Application H09-0843-25
Location Chestnut House North Pennyhill Holbeach PE12 8DN
Proposal Details of doors and windows (Conditions 5 & 6 of H09-0122-25)

Name Greg Watkinson
Address Conservation Officer

Drawing
CONDITION COMPLIANCE
ALUMINIUM DOOR FRAME DETAILS

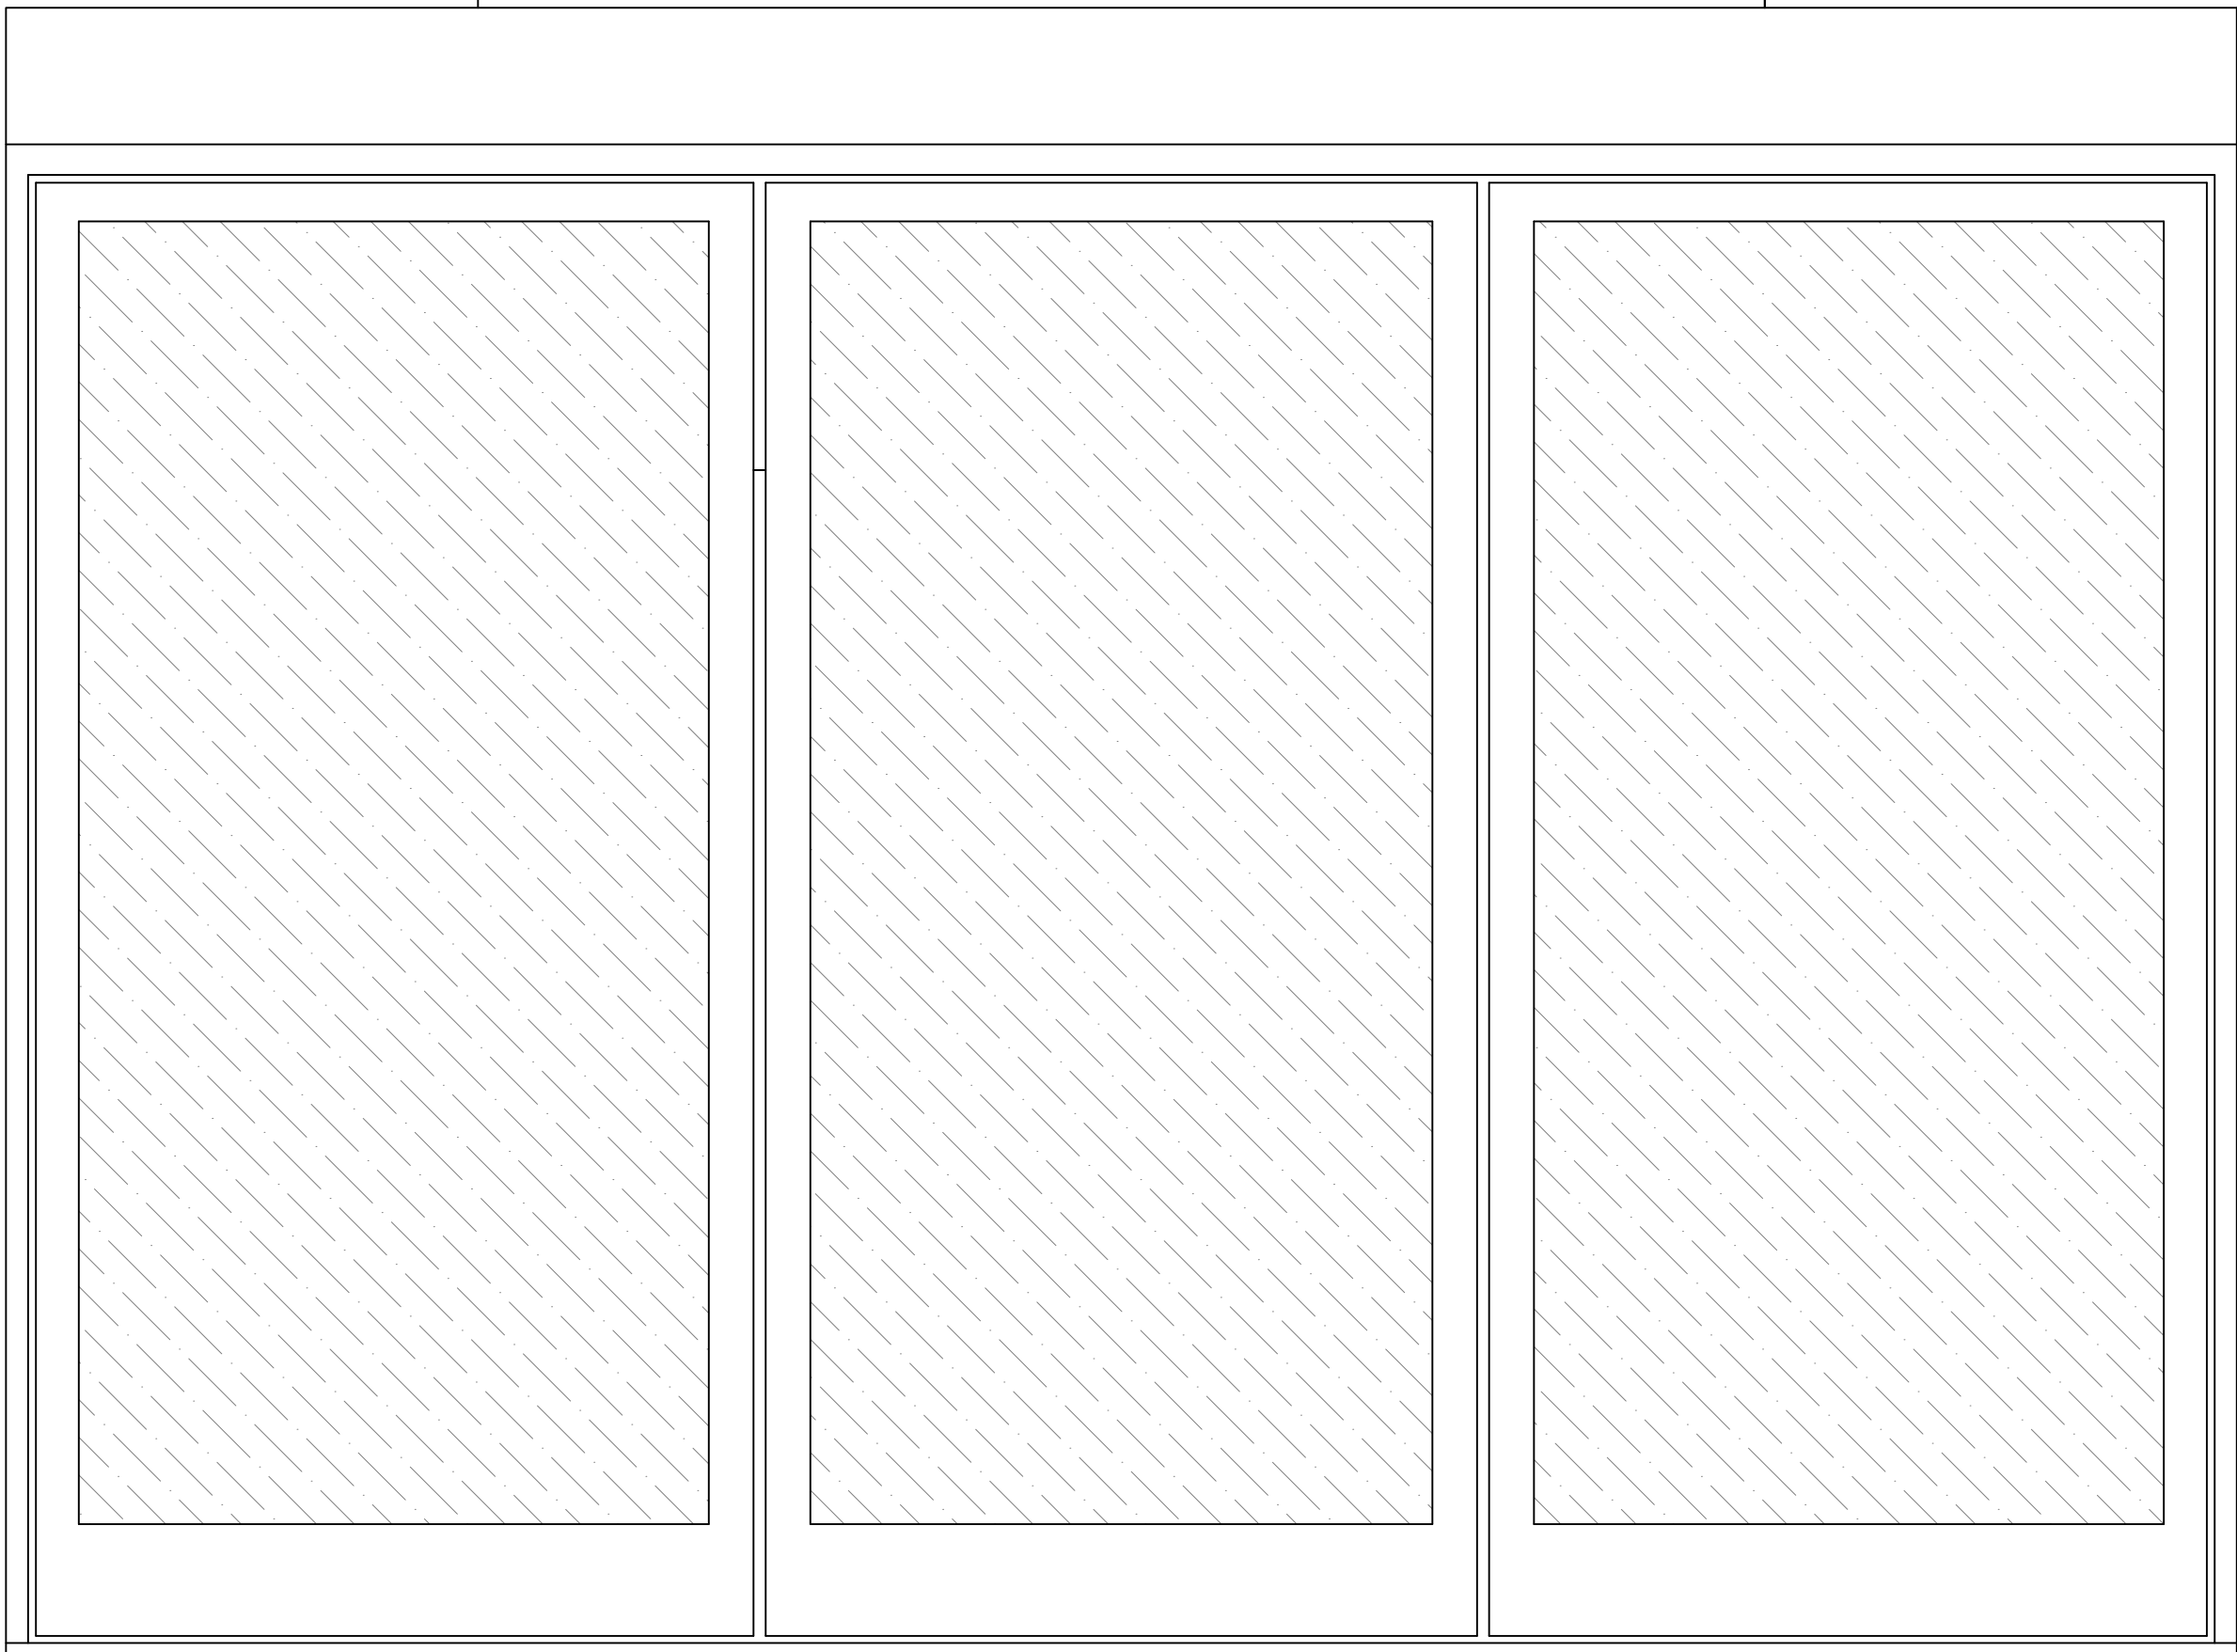
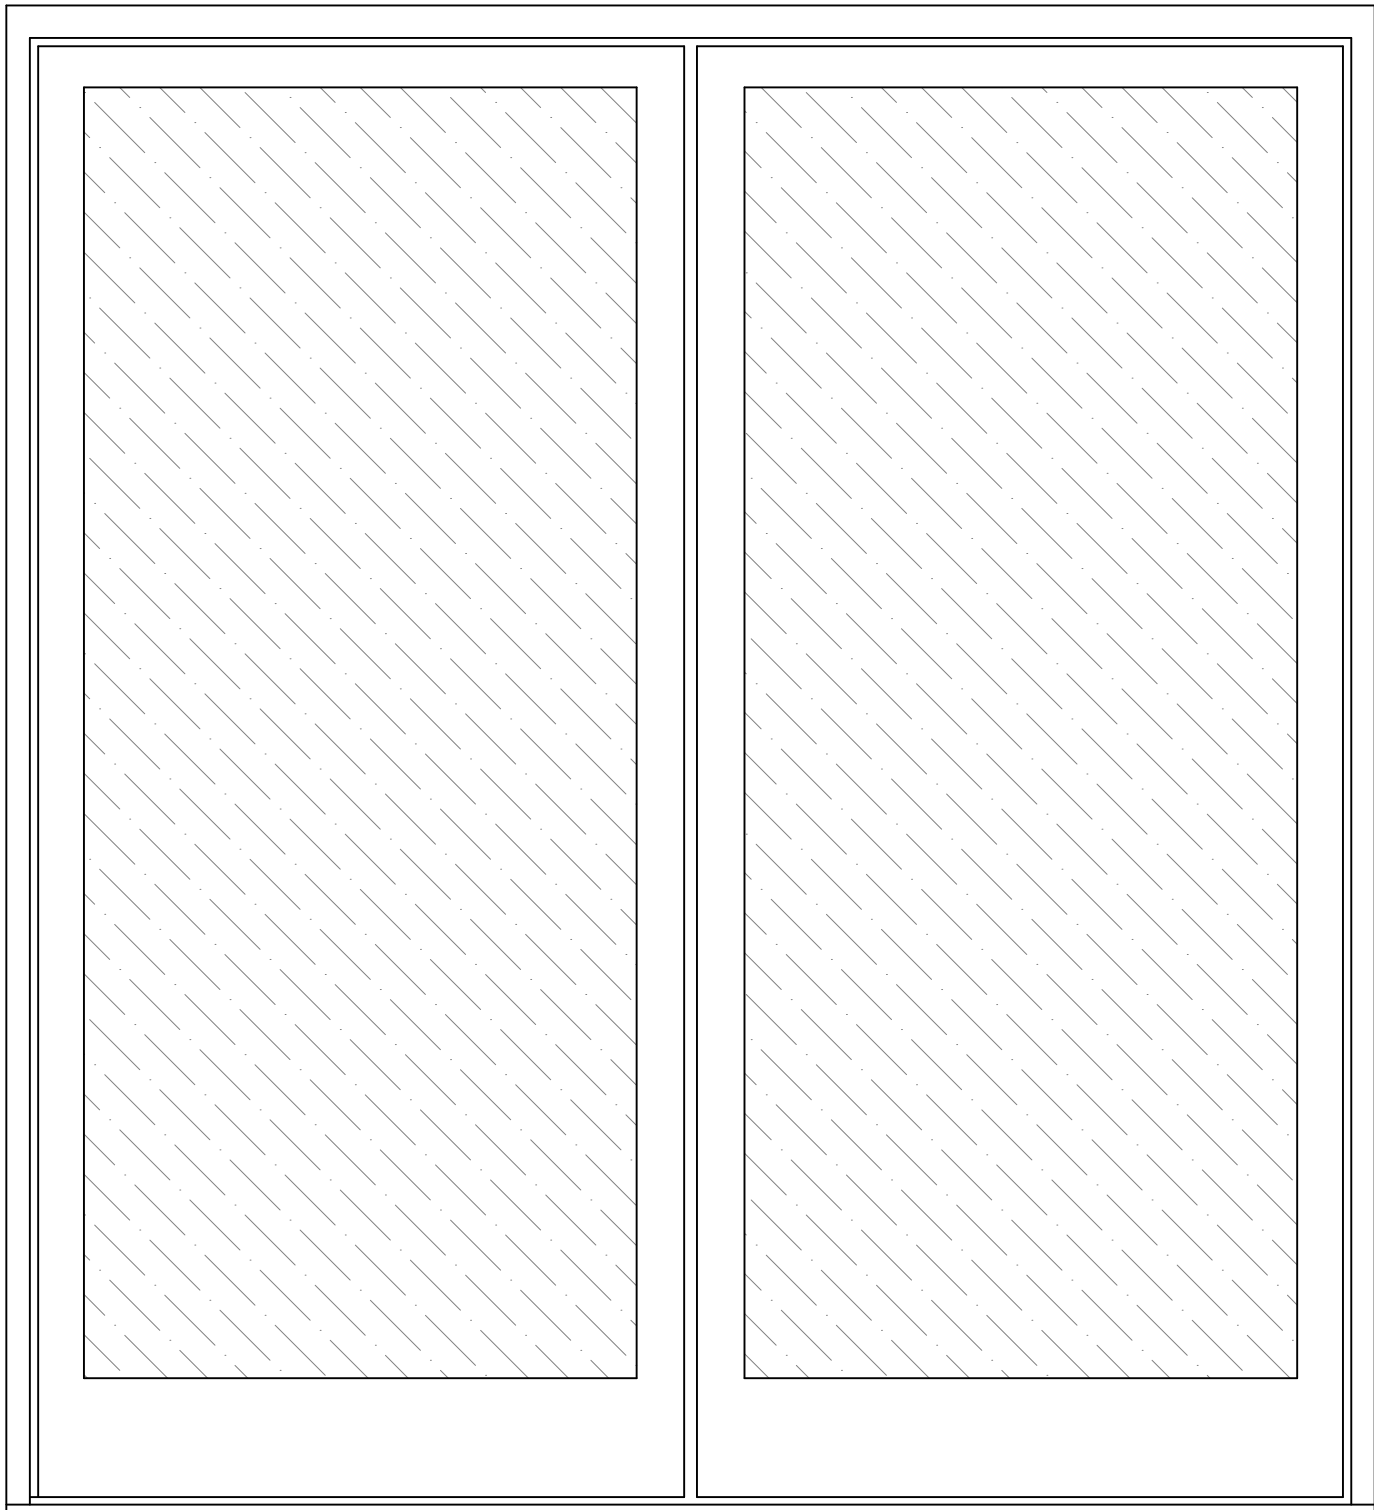
The applicant seeks the use of aluminium-framed, double-glazed fenestration. This is not typically considered to be an appropriate form for use in listed buildings. However, in this instance, the proposed new fenestration is purely for use within the newly approved section / link extension, which features a design philosophy intended to create a visual distinction between the old and the new. Therefore, use of such fenestration in these specific portions of the site is not considered to be a form of harm.
